Traffic Impact Study

Crossroads-Meadowbrook & Reagan Ranch Colorado Springs, Colorado

PCD File No. CR201 & SP207

MEADOWBROOK PARKWAY ROUNDABOUT

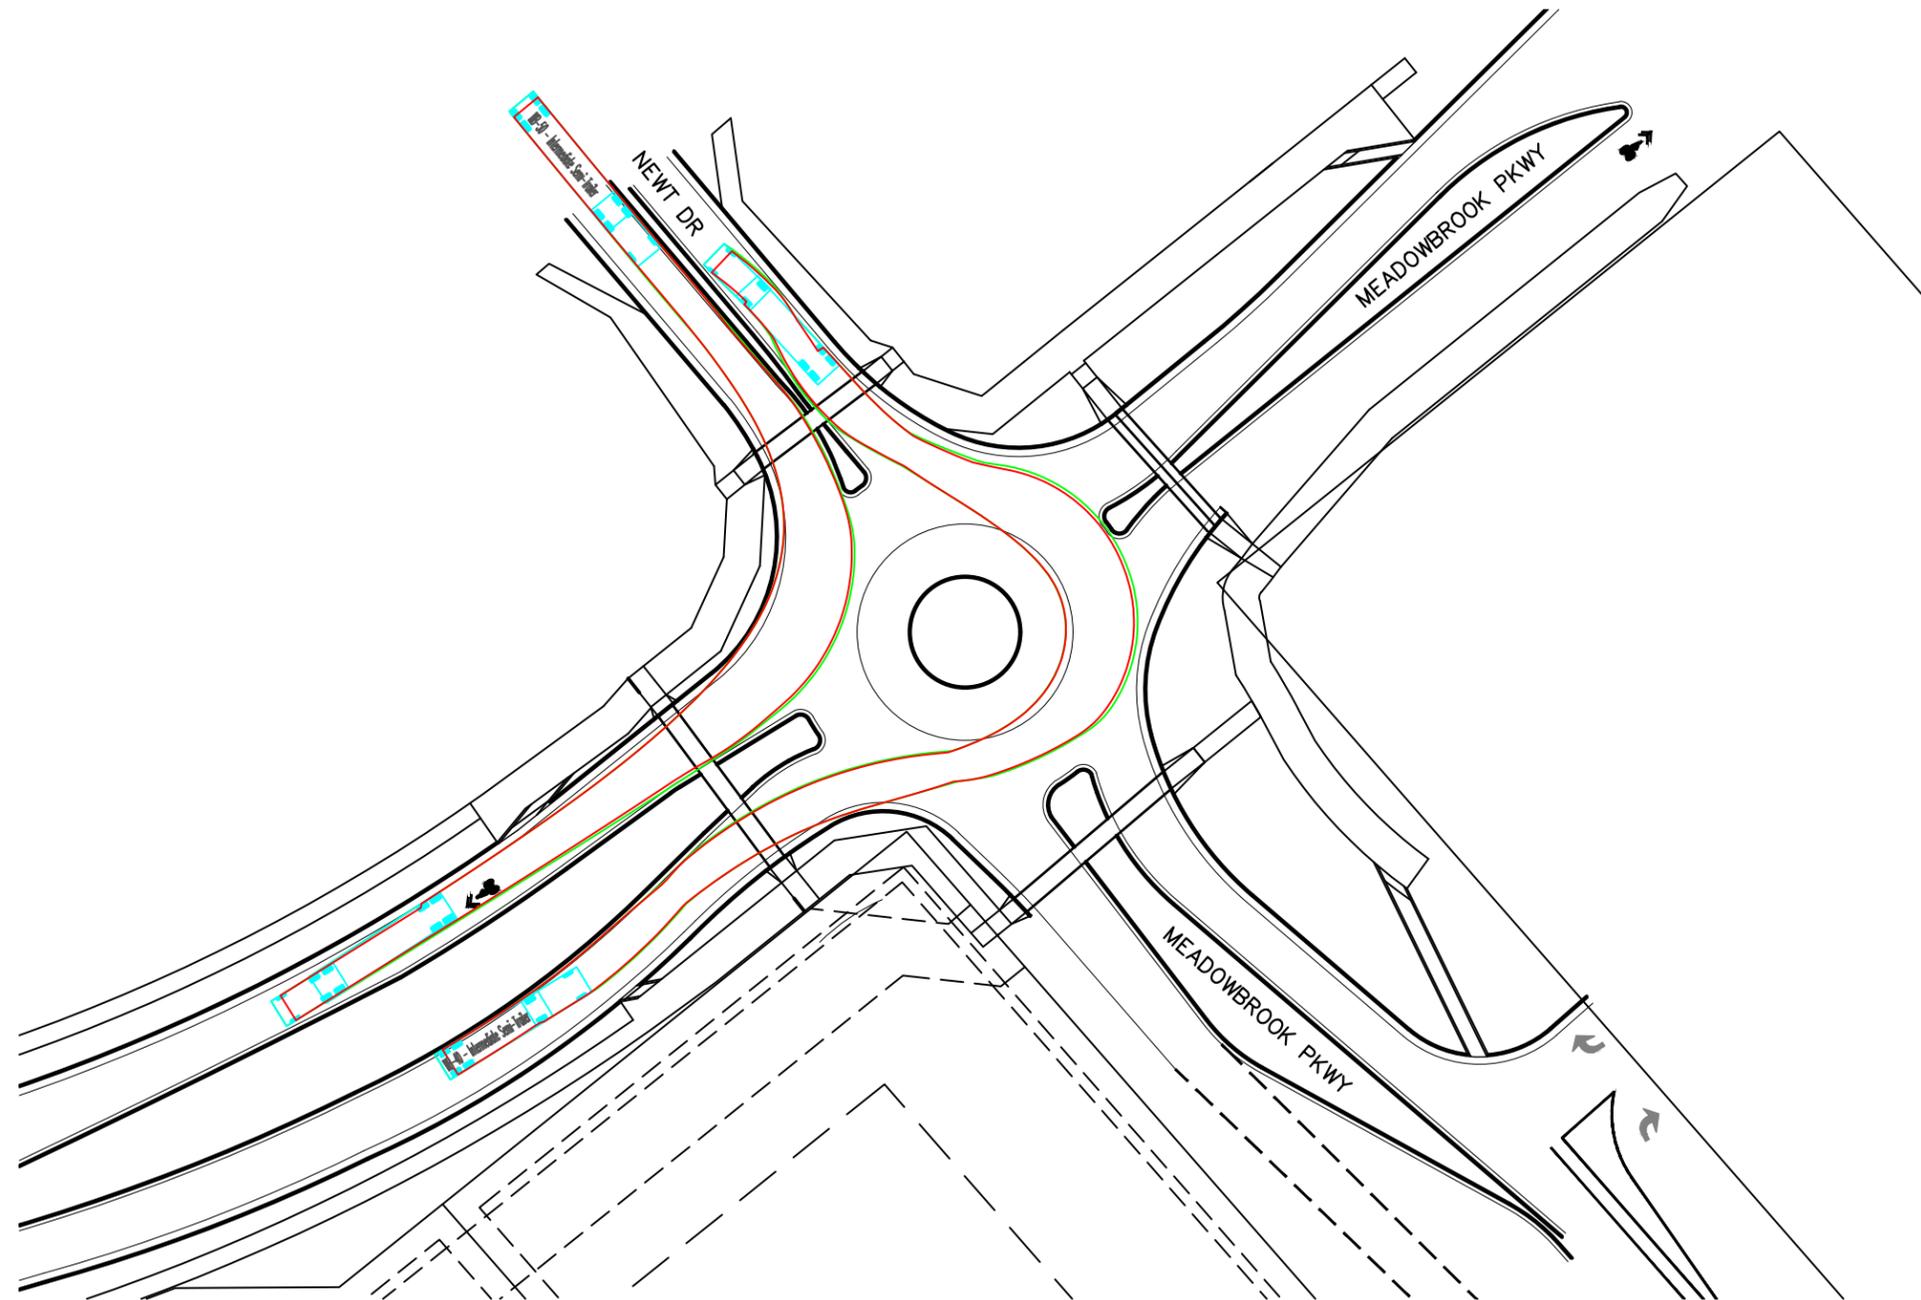
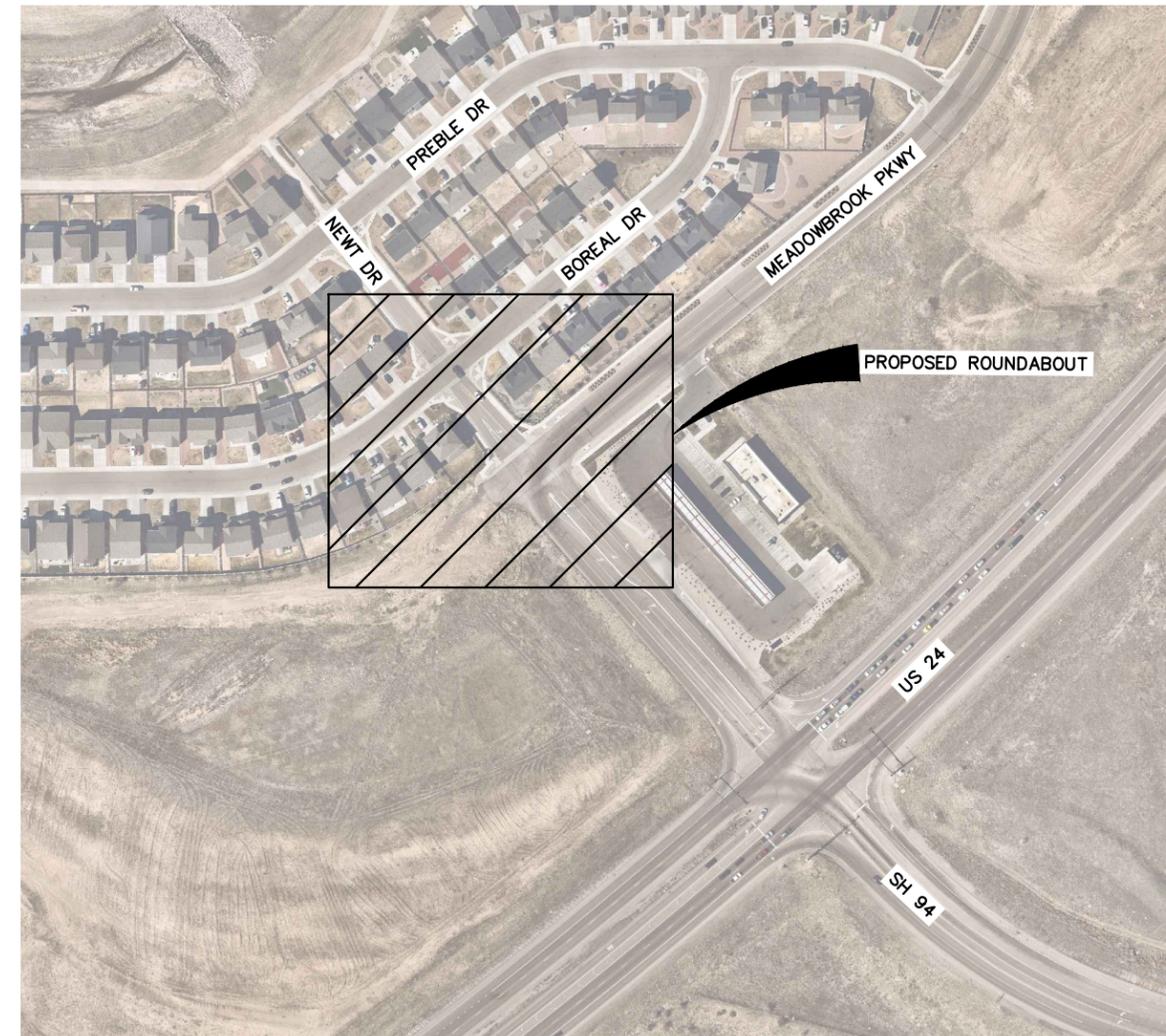
This Master TIS must also include site specific recommendations since this is provided as the supporting TIS for the preliminary plan applications for Crossroads Mix Use (SP2011), Meadowbrook Park (PUDSP208), and Crossroads North (SP207). Please look at the review comment to the TIS under each PCD File No. The redline comments to the TIS were specifically focused for the given project. This revised TIS appears to have only addressed review comments provided under the SP207 submittal. See SP2011 and PUDSP208 review 1 comments for additional TIS comments. 1. Provide recommendations for the internal private road classification/cross section in Crossroads Mixed Use. The trip generation estimate is 11,554 ADT while the preliminary plan showed an urban local road cross section (design ADT of 3,000) for the internal private road. **Unresolved. It seems the private road should be designed to a non-residential collector cross-section.** 2. Provide roundabout analysis. Current policy is to design per the Wisconsin DOT roundabout design criteria. - Autoturn analysis of the intersection. Per ECM Table 2-7 design vehicle is WB-50. - Table of critical design parameters. - Rodel model report. - Fastest path analysis/exhibit. - Entry angle exhibit. **Unresolved. Address the original comments to make sure the roundabout shown in the preliminary layout is appropriate.**

- 1) An internal roadway evaluation has been provided with roadway classification and cross section recommendations.
- 2) The future roundabout intersection of Meadowbrook Parkway and Newt Drive has been evaluated with Rodel/Arcady software in the traffic study addendum letter.

The requested design criteria and parameters will be provided for the future roundabout intersection of Meadowbrook Parkway and Newt Drive. This design package will be provided separate of the traffic study letter.
